Light Valley Solar

Change Application and Consultation Report

Document Reference: EN0110012/APP/LVS/08.42

October 2026

Drawing Title
Figure 15.1
Surface Water Features
Sheet Number 1 of 9

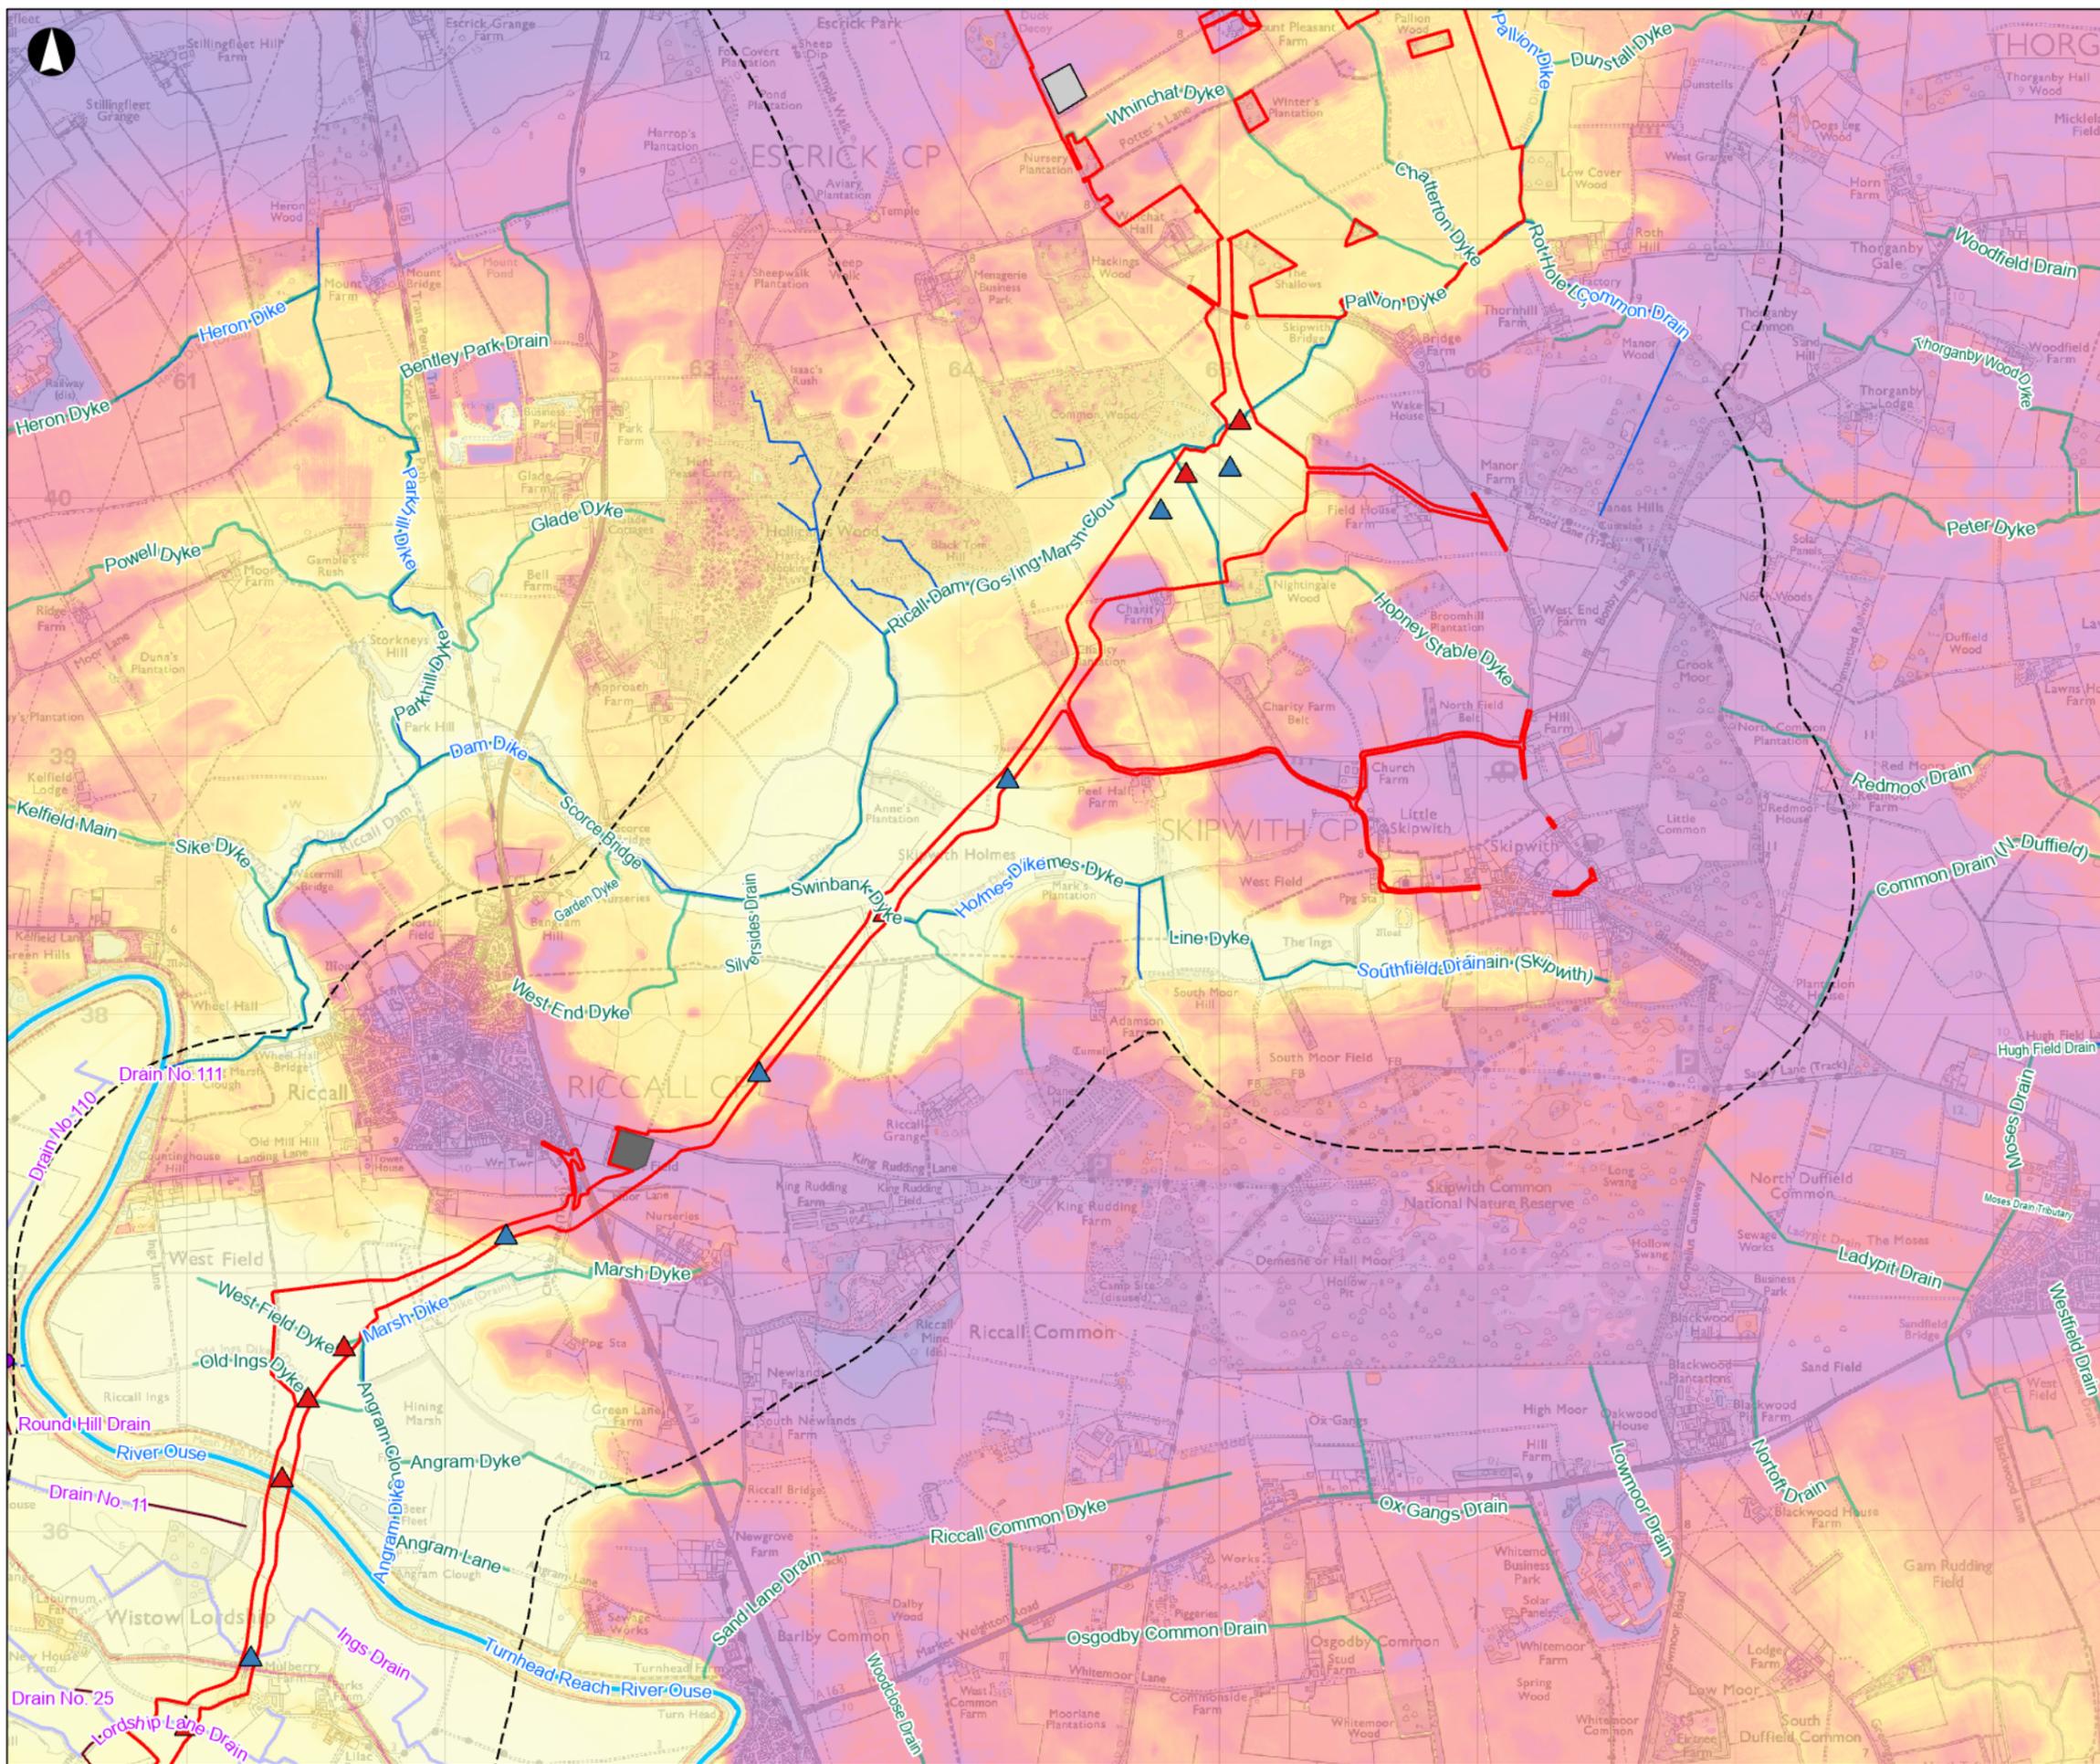
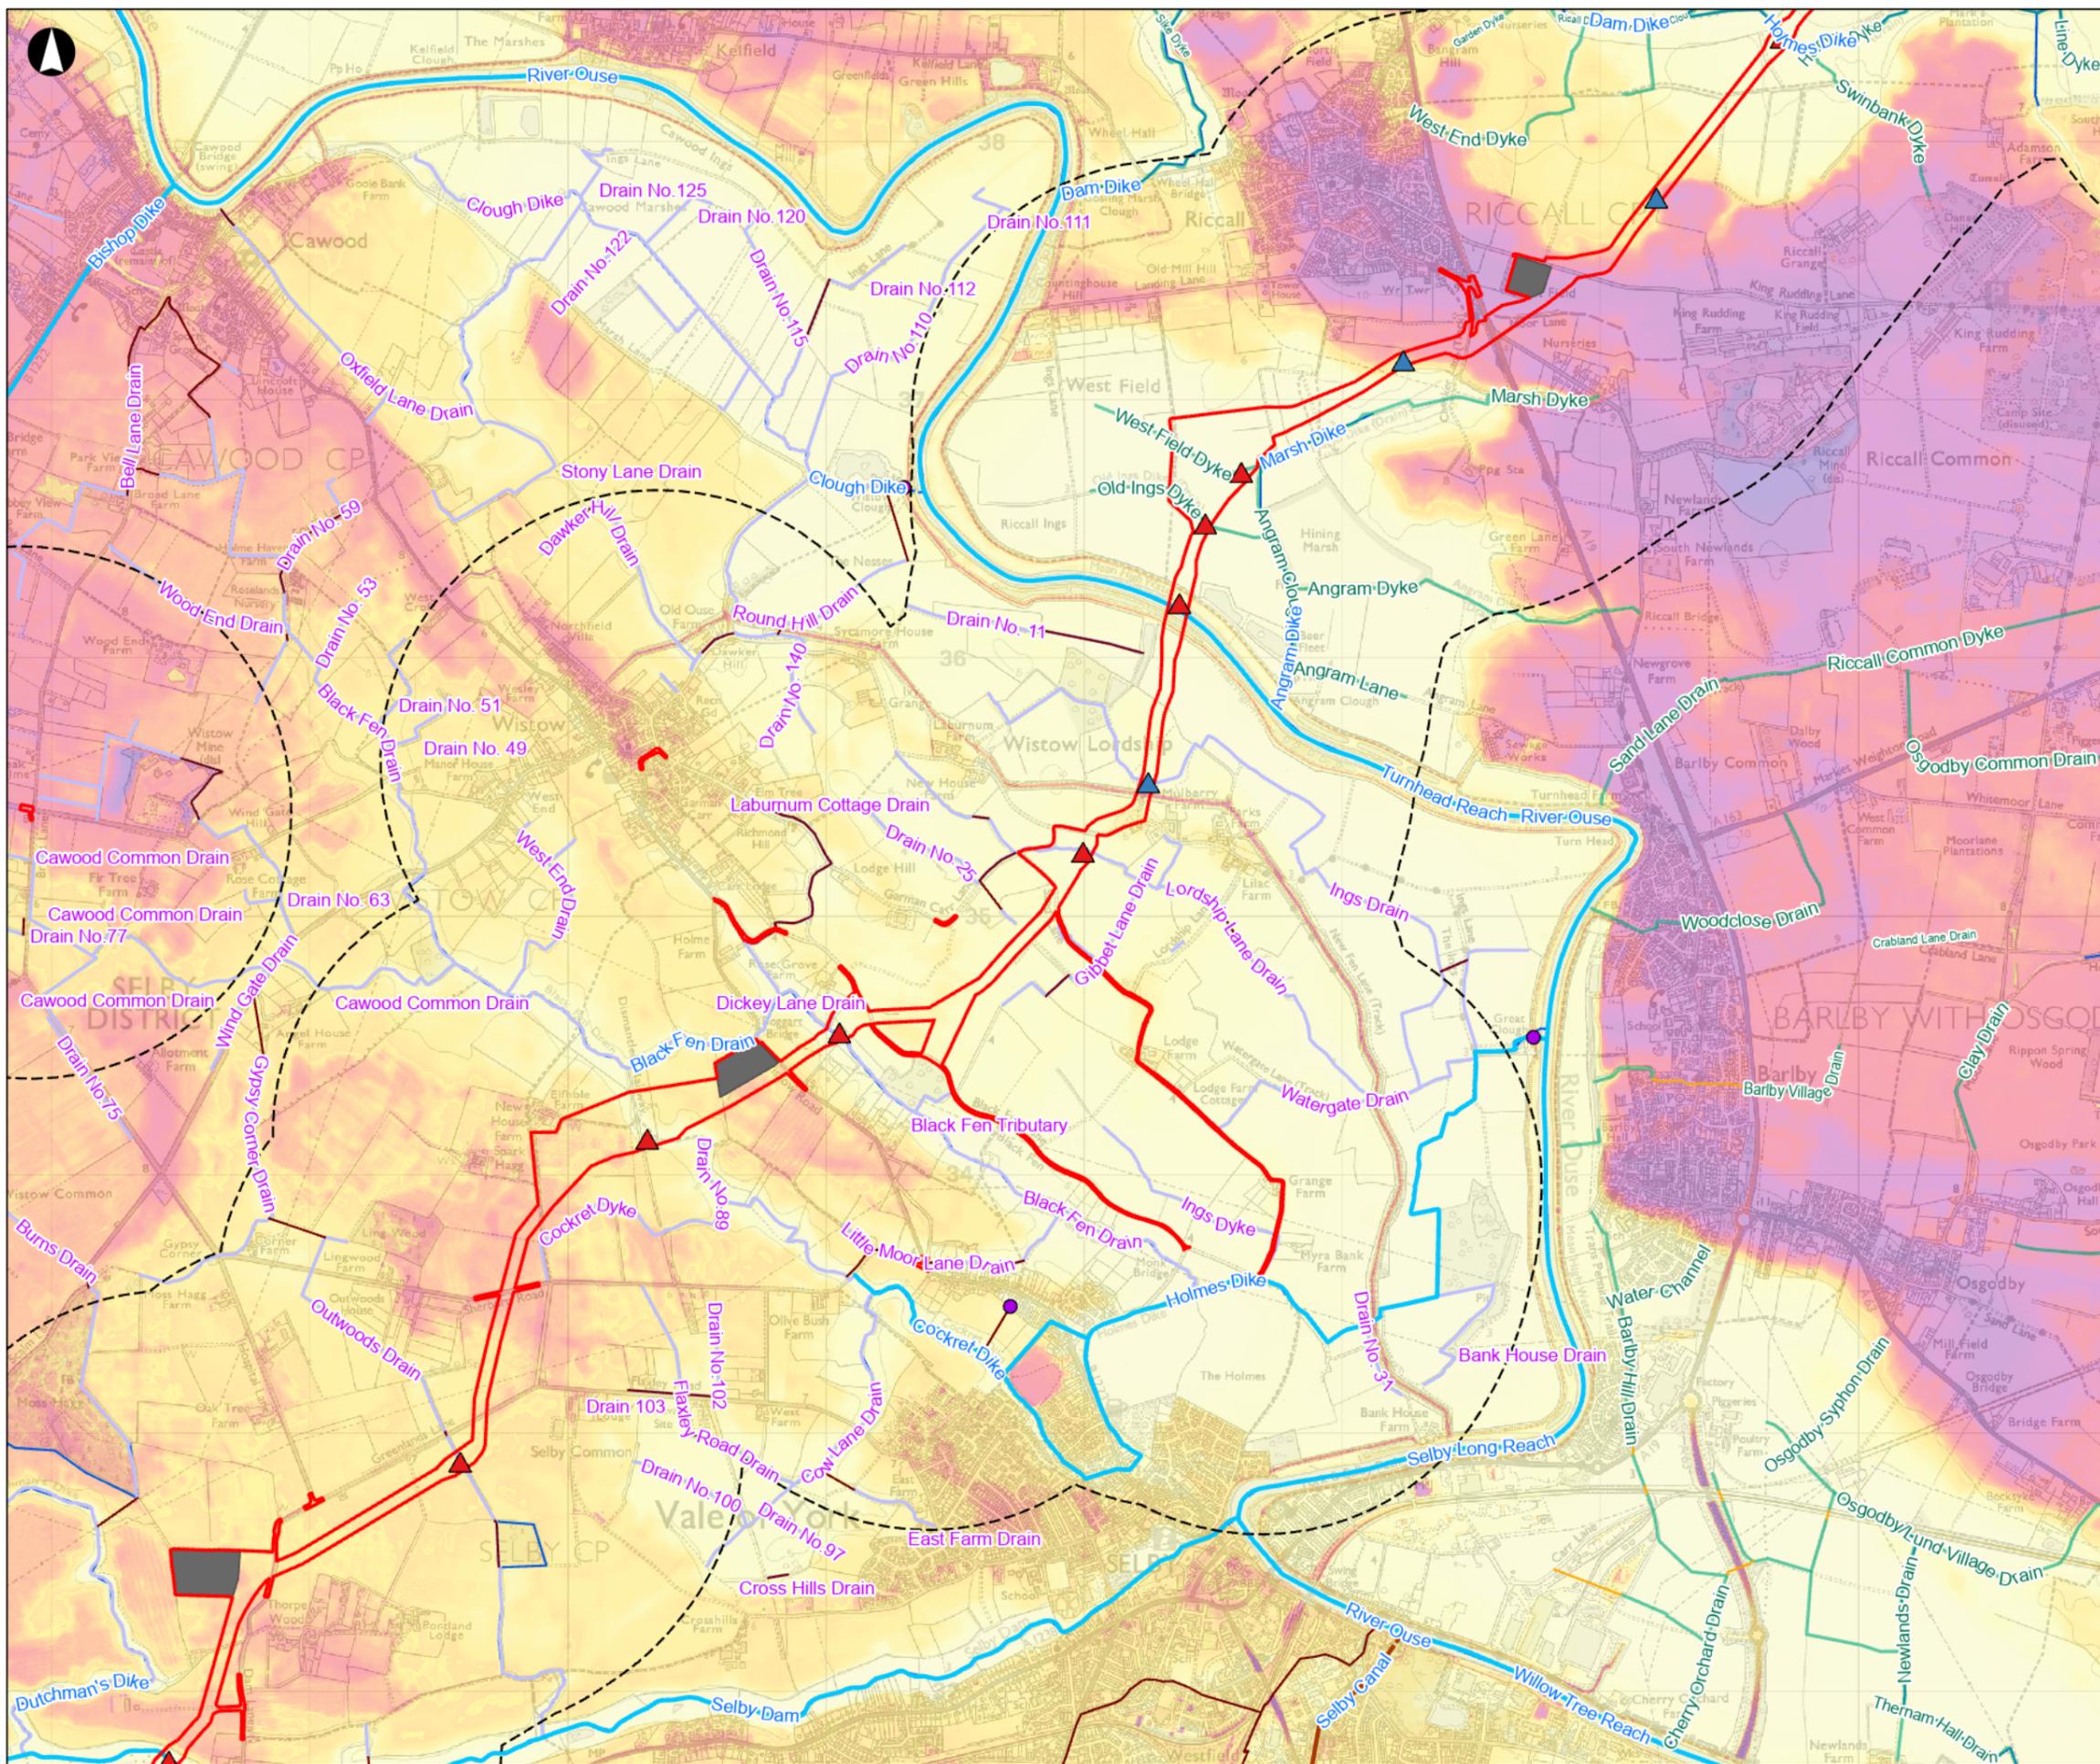
- 3.3.3 As set out within the Applicant Technical Note Plot Size **[REP2-115]**, this section on the Cable Route Corridor is constrained by an Internal Drainage Board Ditch (IDB) ditch (refer to ES Volume 2, **Figure 15.1 Surface Water Features [APP-115]**) which the Applicant has committed to cross using a trenchless solution (refer to ES Volume 2, **Figure 2.5 - Avoidance Areas [APP-062]**). The breadth of the Cable Route Corridor in this location allows for micro siting of the cable and trenchless works during the detailed engineering design work. The Order Limits also captures an existing culverted crossing in the west of the Cable Route Corridor which would be used for access where practicable, rather than introducing new temporary culverts.

- 3.3.4 Subsequent analysis has identified that full width of the Cable Route Corridor north of the IDB ditch is not required for laying of Interconnecting Cables, but this area is still required to facilitate construction vehicle access. Change 7 therefore comprises a reduction in the Works No.5 area and an increase in Works No.8a to reflect this, whilst also facilitating a reduction in the amount of permanent rights required (and thus downgrading to temporary possession only powers to be sought).
